Consultation Response from: KC Environmental Health (Pollution & Noise Control)**2024/90664 Unit C9a Ground Floor, Carlinghow Mills, 501, Bradford Road, Batley, WF17 8LN****Change of use from offices to nursery, erection of front porch, formation of parking area and associated external alterations (within a Conservation Area).****Date Responded:**
25th June 2024**Responding Officer:**
RM**Responding Ref:**
WK/202418039**Contaminated Land**

Drawing Title:
Proposed Area Plan

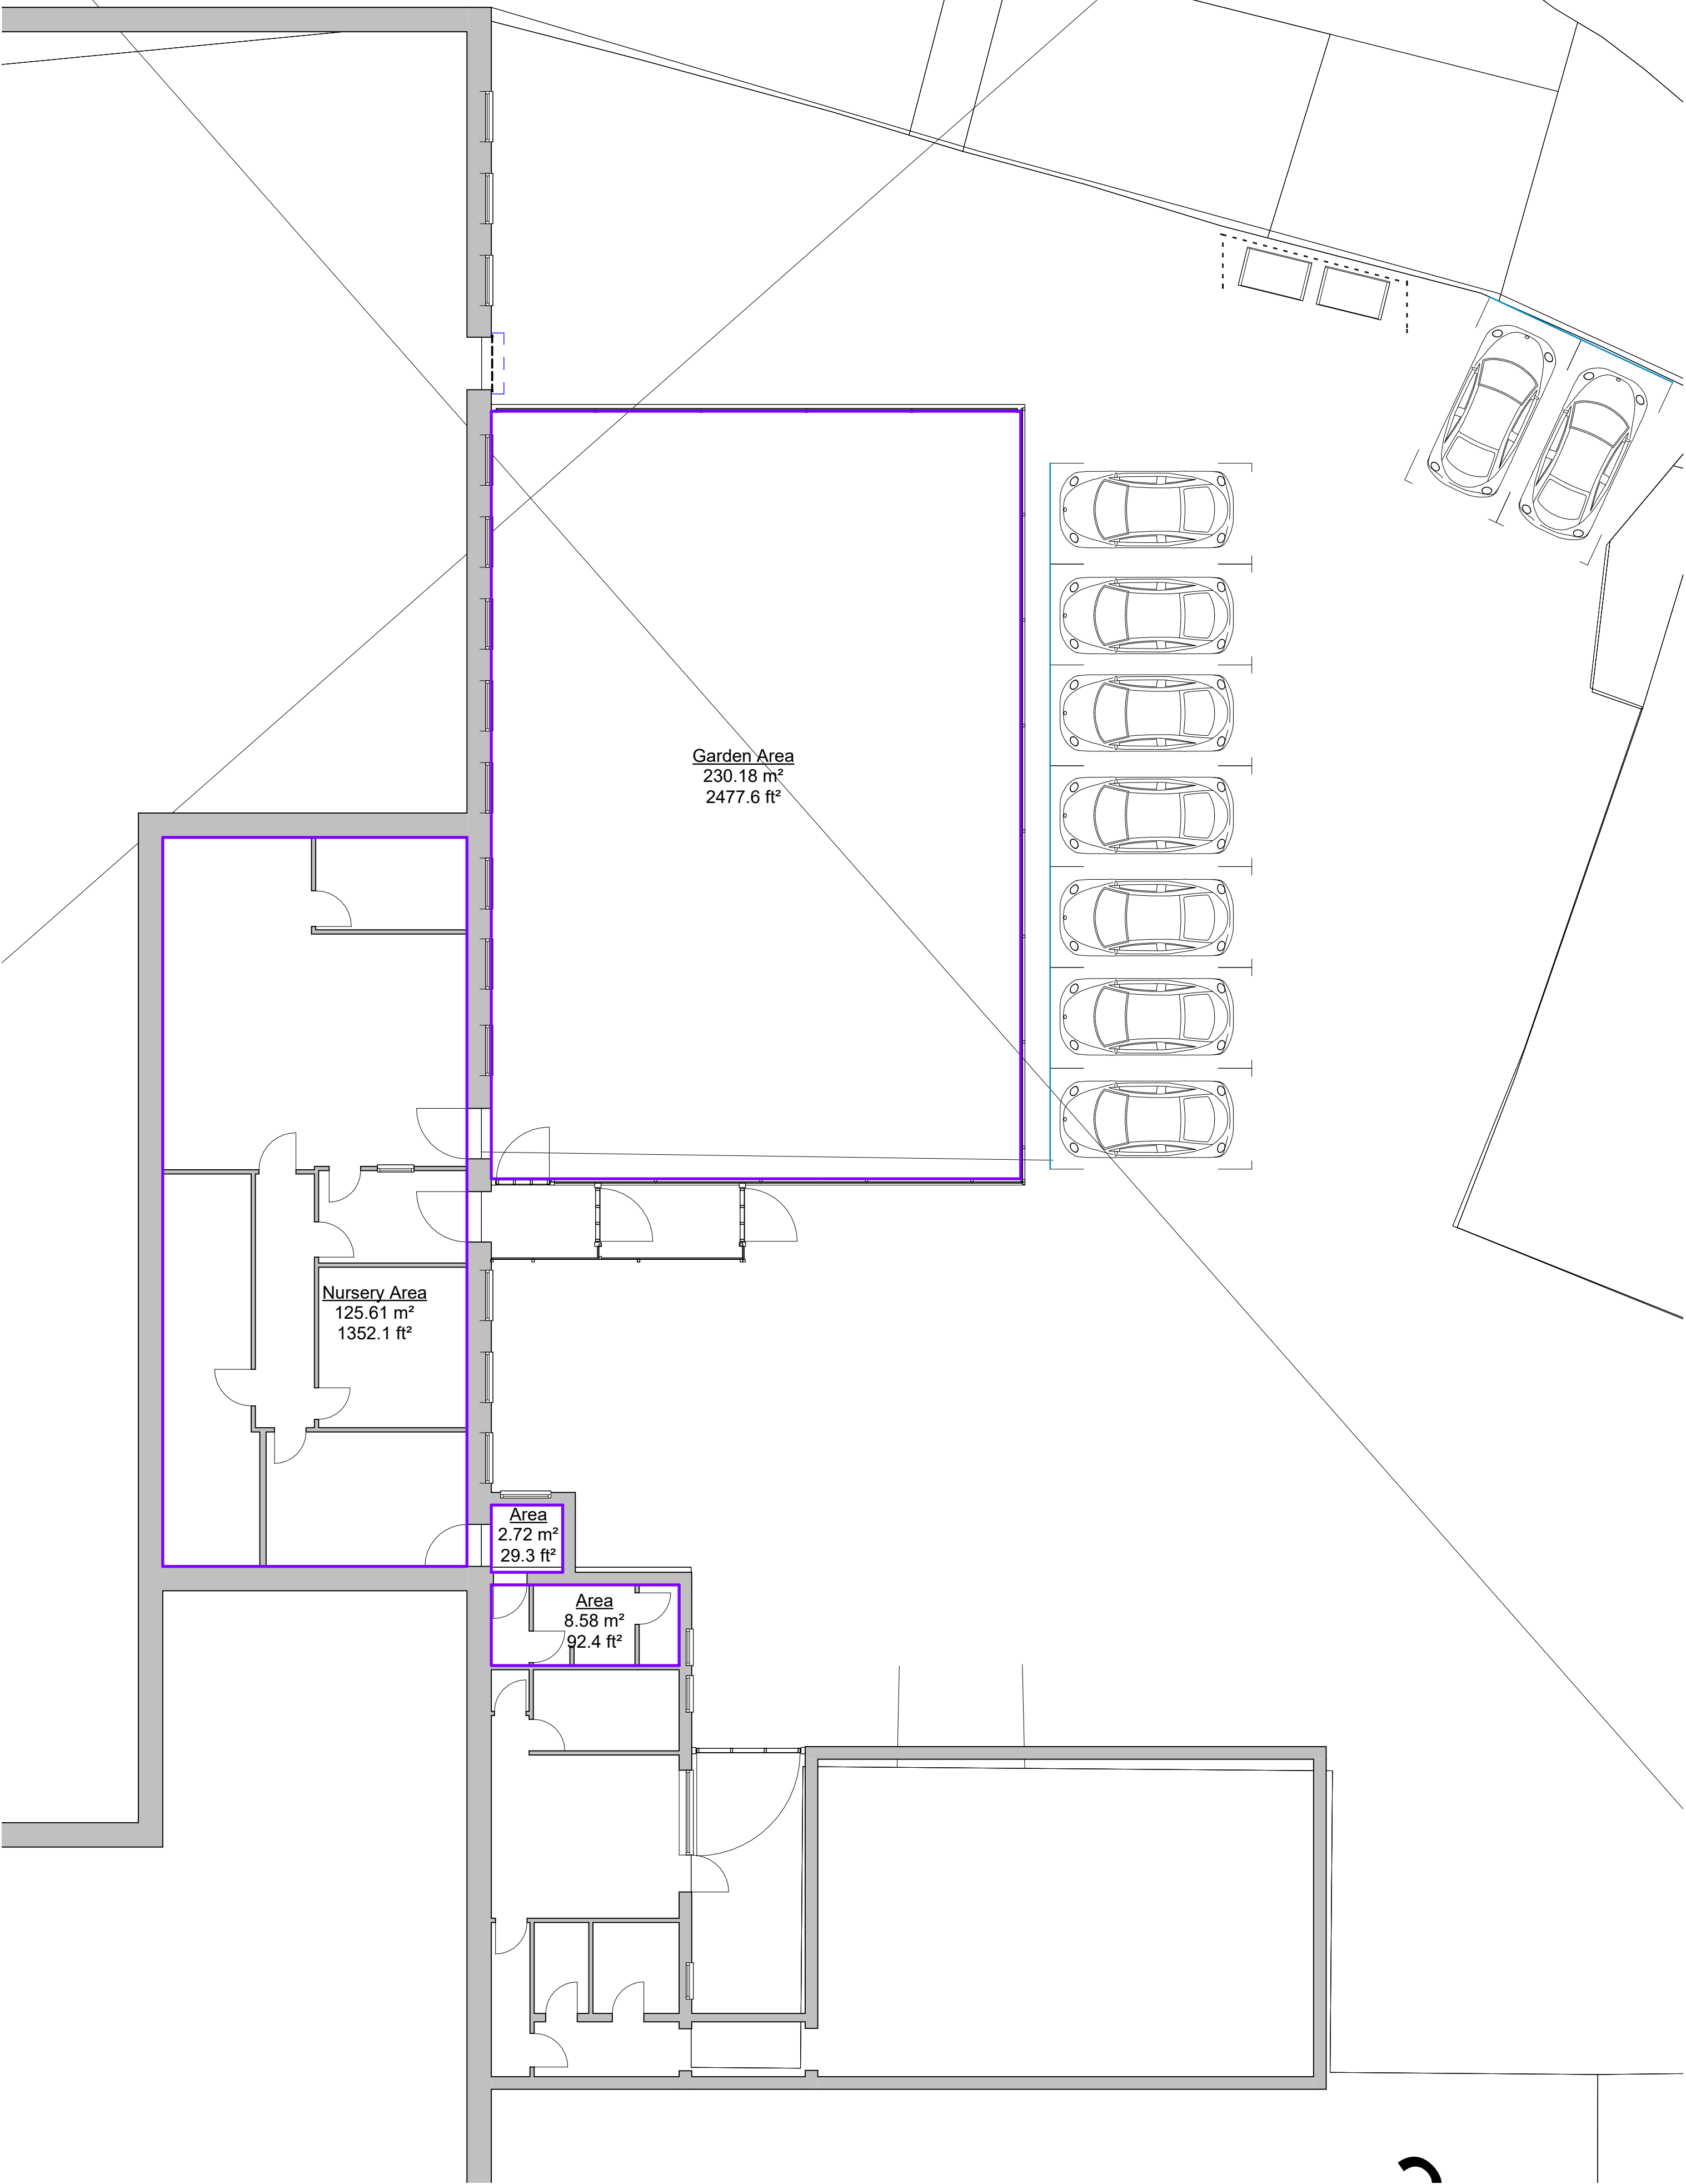
The site of the proposed outside garden play area is on land that is potentially contaminated due to its former use. No detailed information has been provided regarding the existing and proposed cover. We consider that a potential pollutant linkage exists therefore further information is required.

Before we can comment further, we require clarification regarding the adjacent uses of the building on the ground, first and second floors of the building whose amenity may be impacted by noise from the proposed nursery and outside garden play area.
